Planning Application – LU/116/19/PDH – LU/290/19/HH
62 Parkside Avenue Littlehampton BN17 6BJ

Mrs. J. Belchamber
64 Parkside Avenue
Littlehampton
BN17 6BJ

16th October 2019

Drawing Title
**Part of Proposed Floor
Plans.**

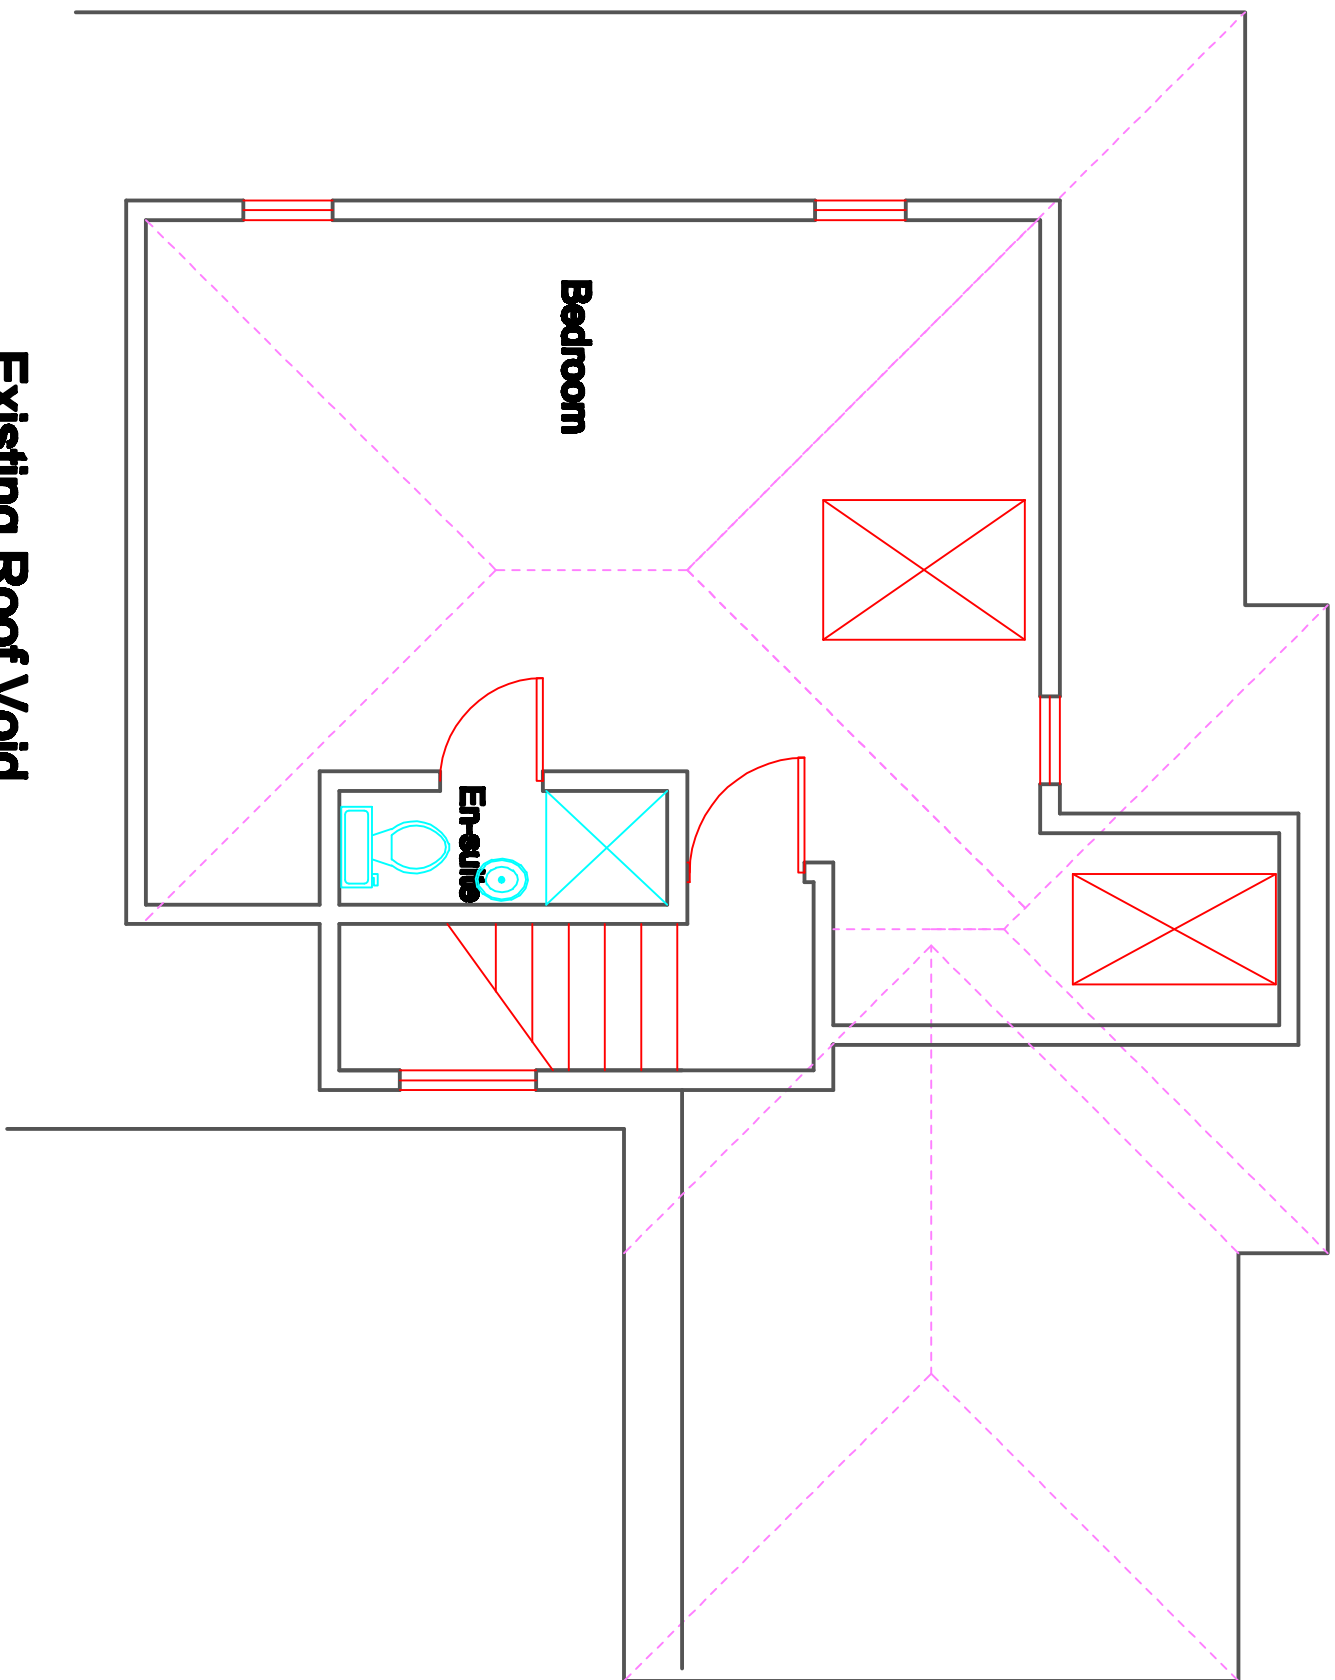
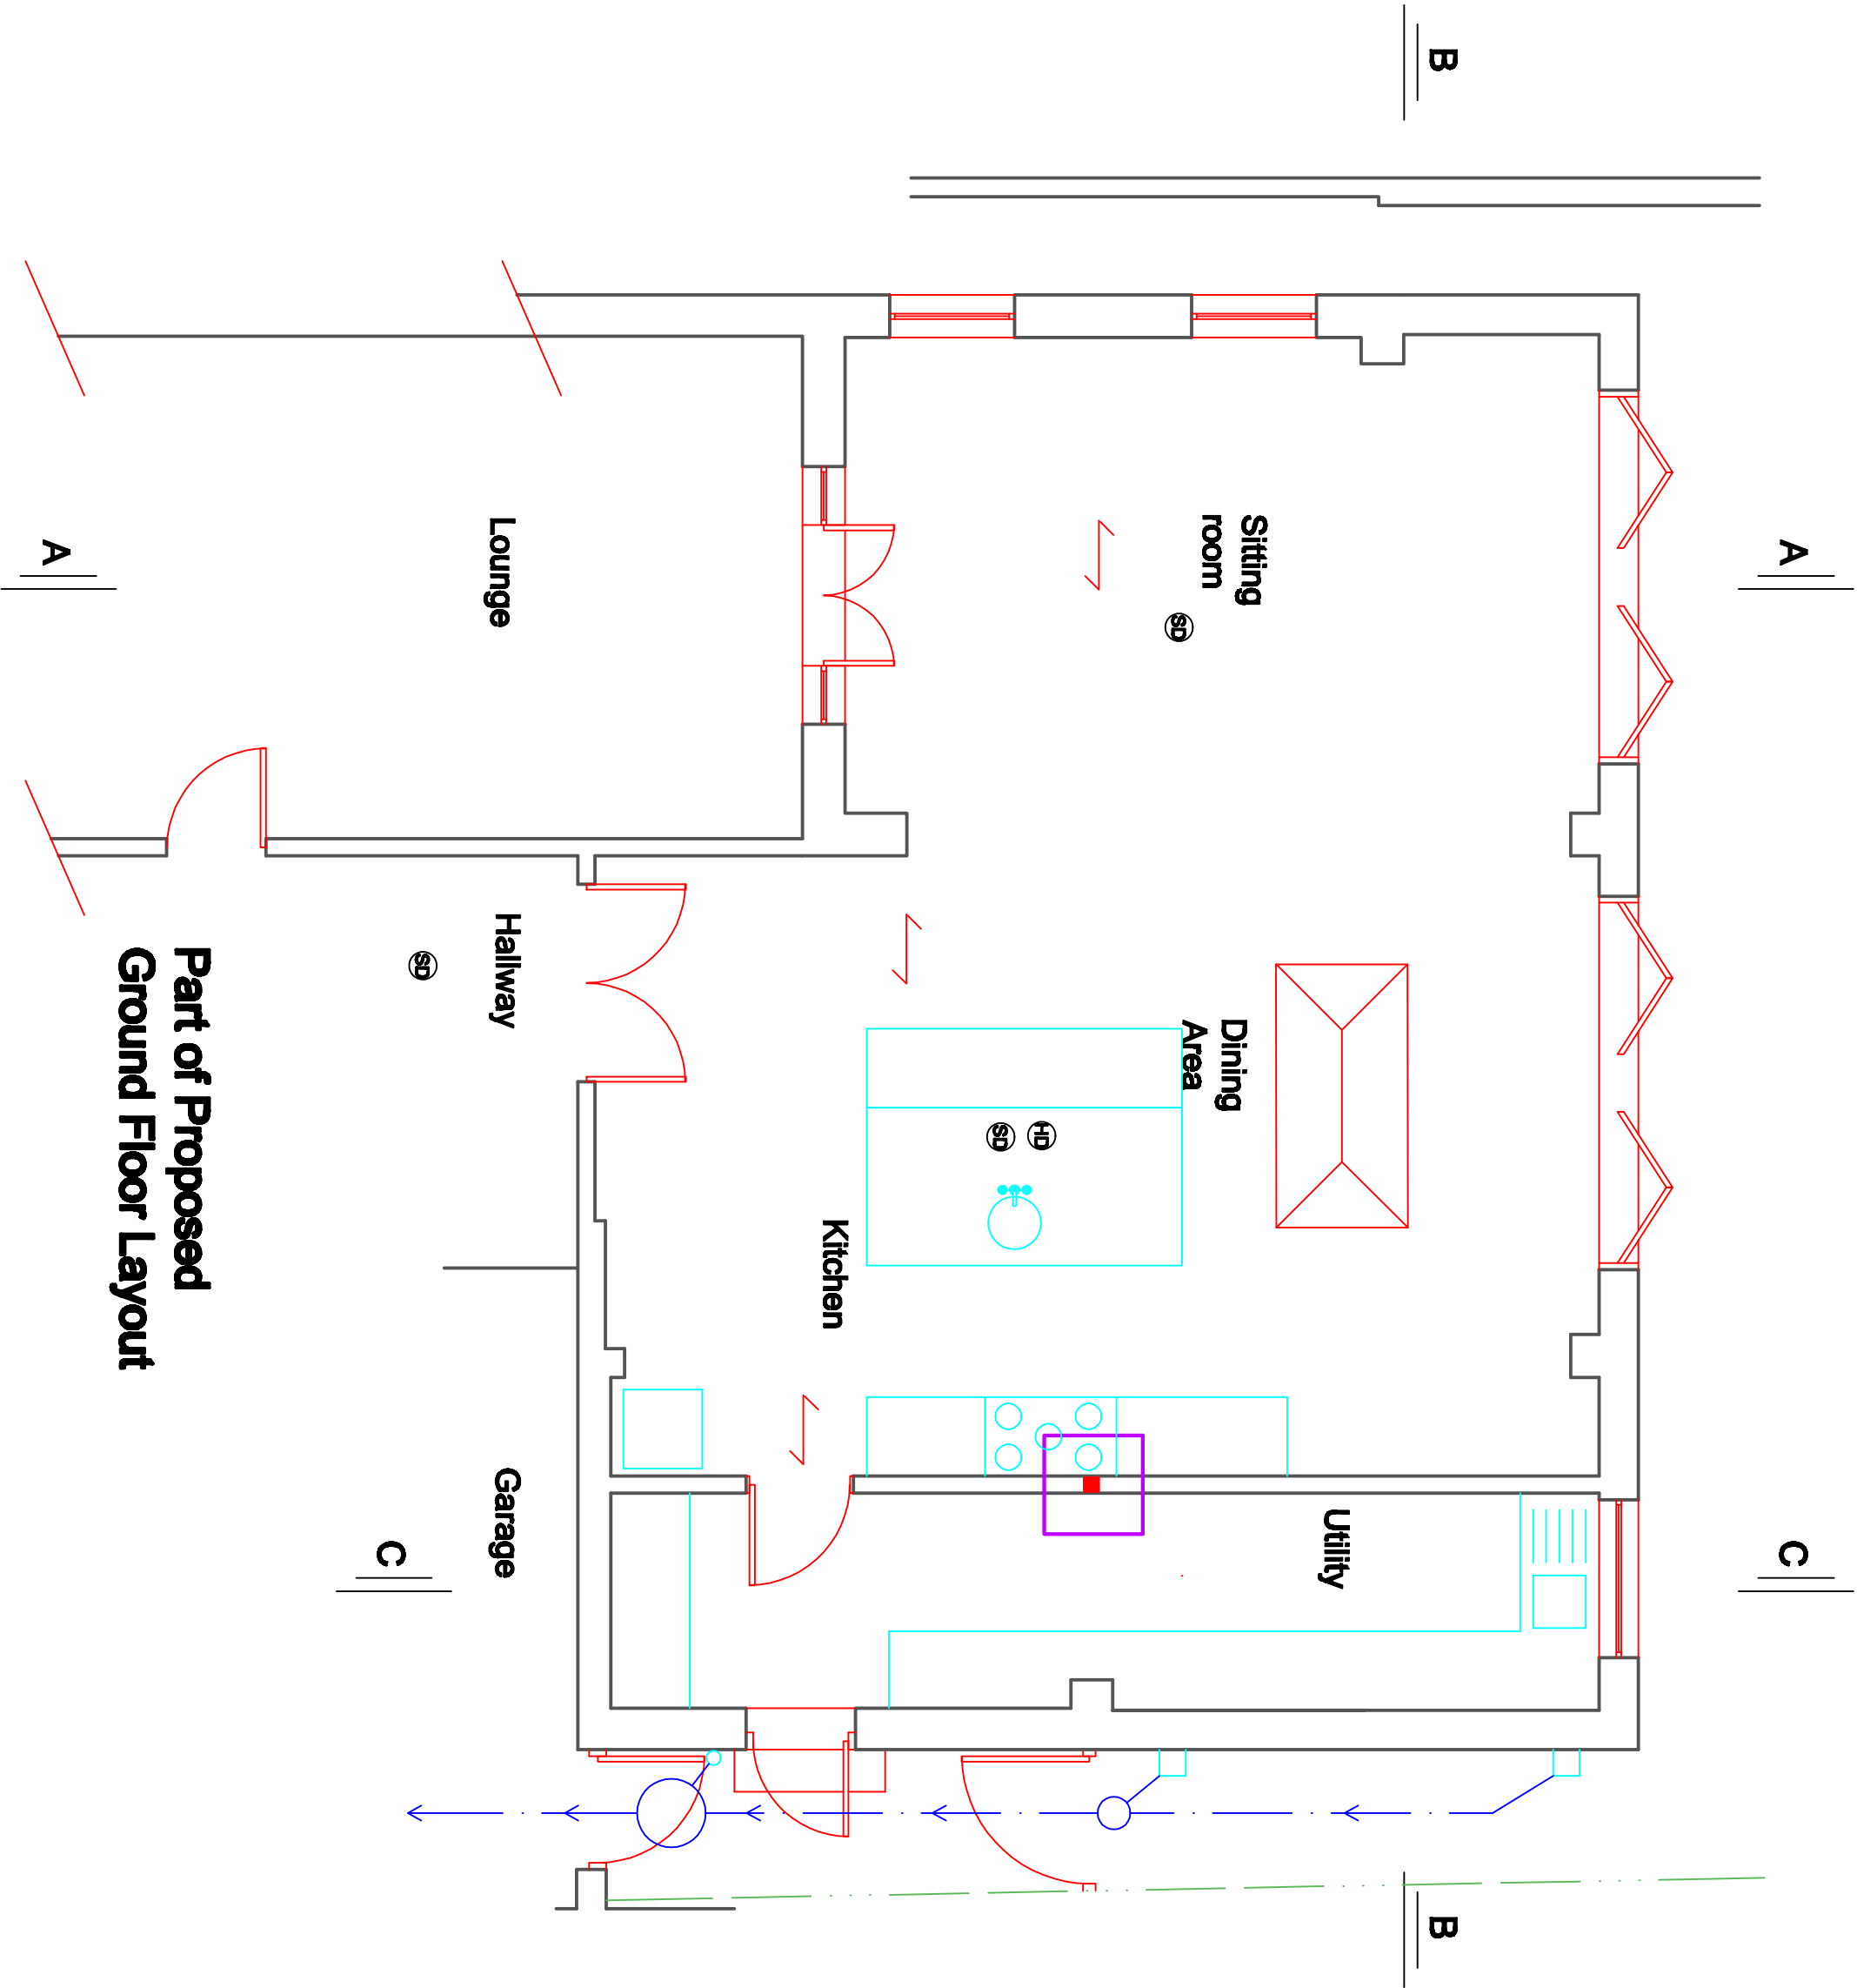
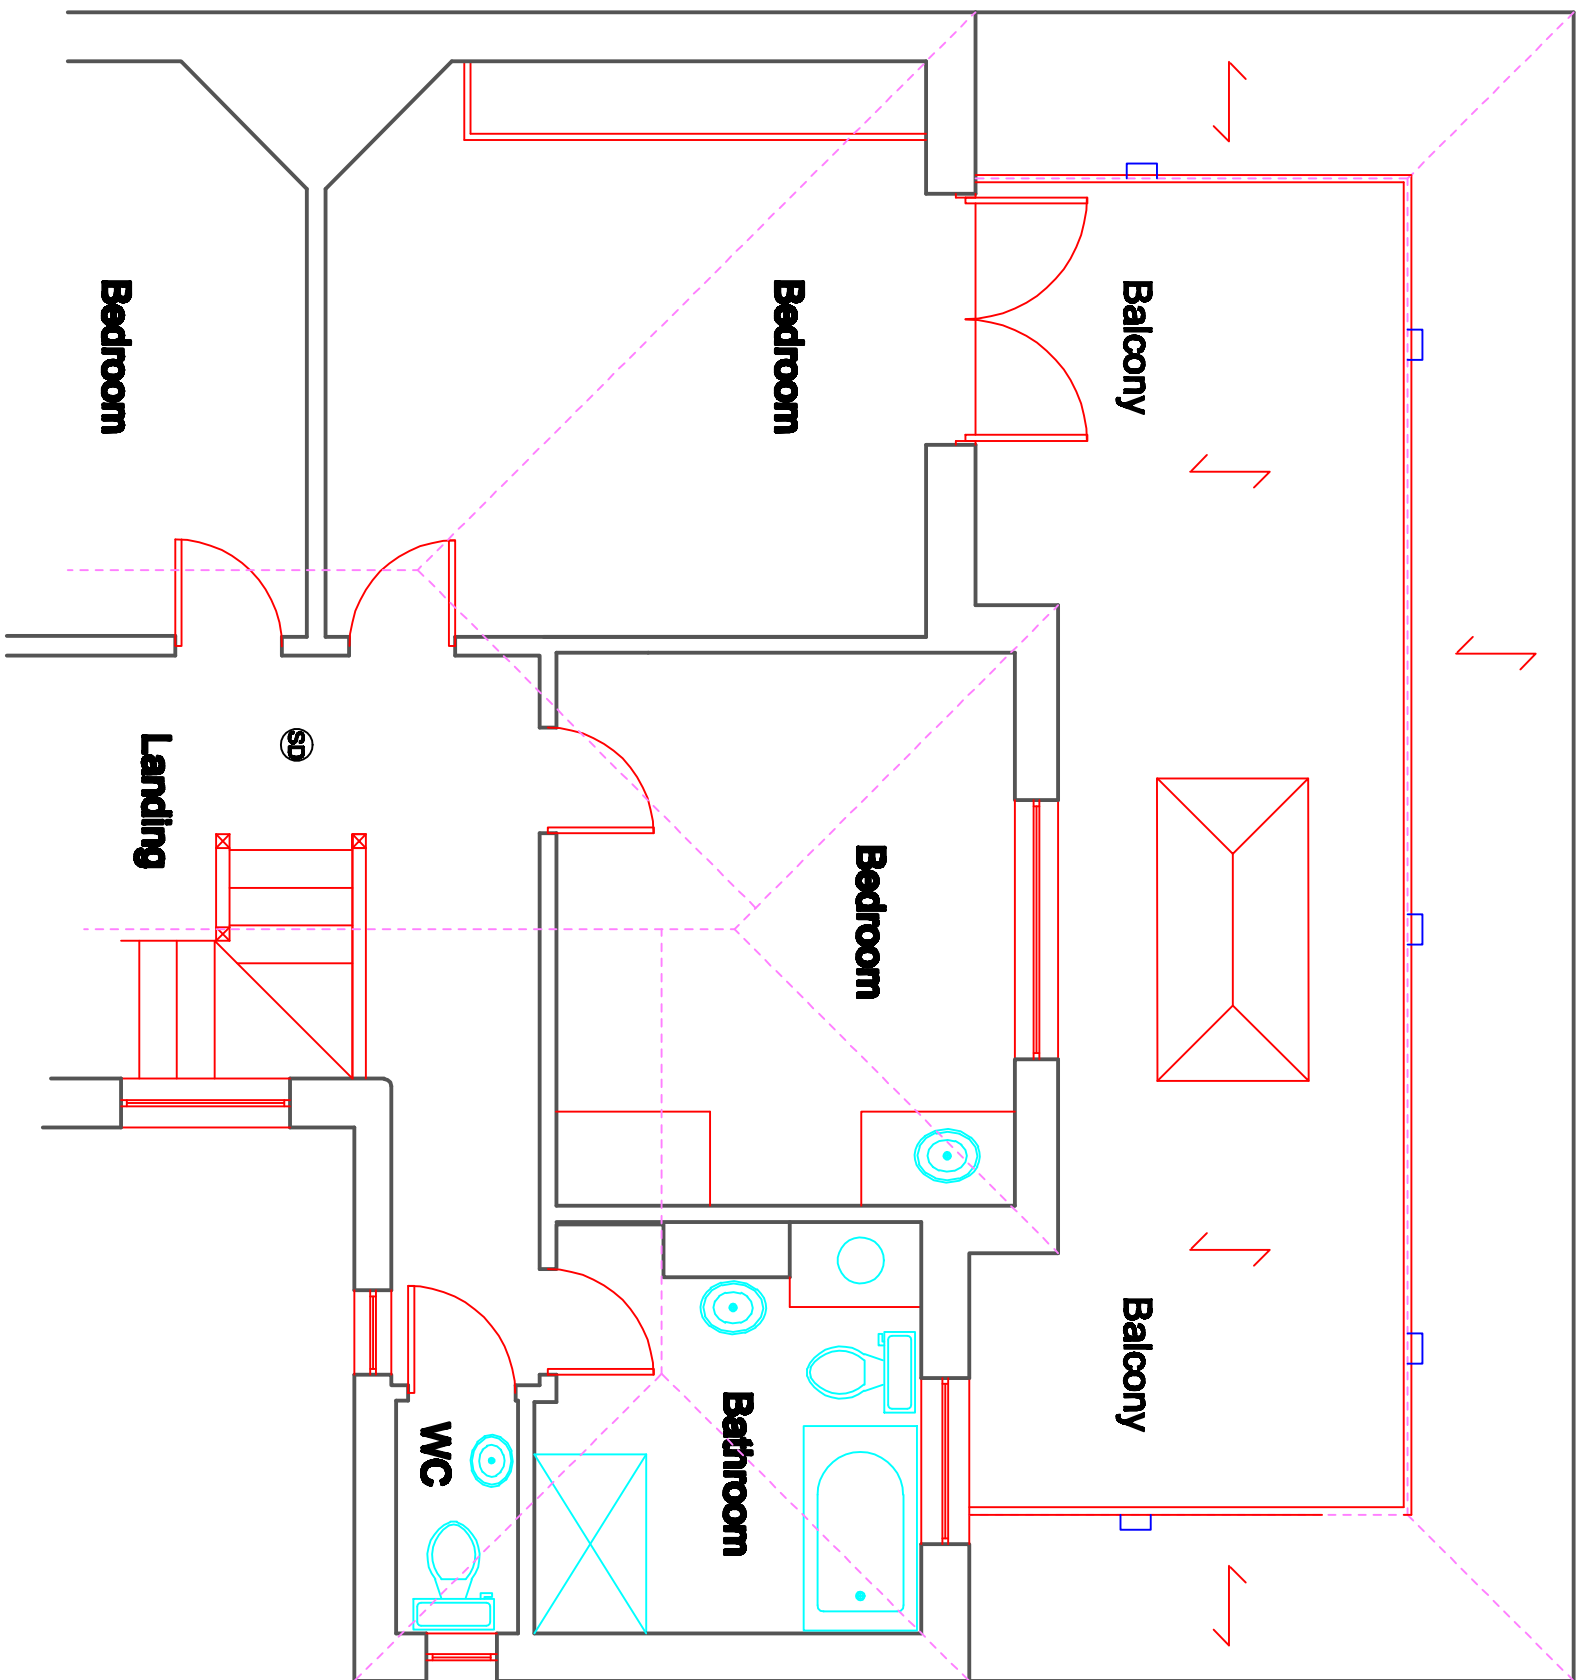
I consider the proposed extension to this already large property which has 5 bedrooms and 3 living rooms to be overdevelopment of a property which is in such close proximity to the properties on either side i.e. 60 & 64 Parkside Ave. This property has had 3 extensions in recent years - a double garage, the addition of a third floor and a sun lounge.

I particularly strongly oppose the provision of a balcony on top of this extension as this would be a total intrusion of my privacy. Being about 10ft forward of my property and only 2ft from my boundary it would mean there would be nowhere on my patio and back garden or sunroom where I could sit and relax or work without being overlooked. Anyone on the balcony could also look straight through into my bedroom and lounge windows. (see photo) I have lived in my home for almost 43 years and I feel strongly that I should be able to maintain the same quality of privacy I have enjoyed throughout that time. Added to this there is the potential for noise and possible rubbish generated which also needs to be considered

PROP. ELEVATIONS

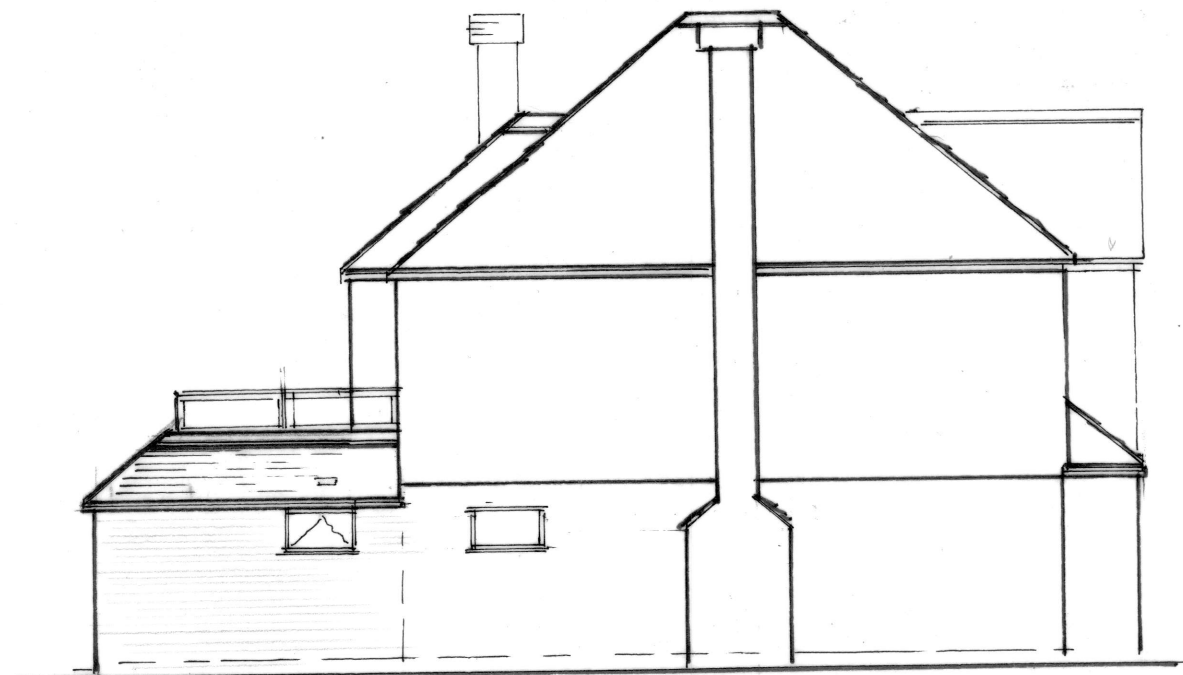
The visual impact of this extension, particularly the balcony, would be totally out of keeping with any of the other properties in the street.
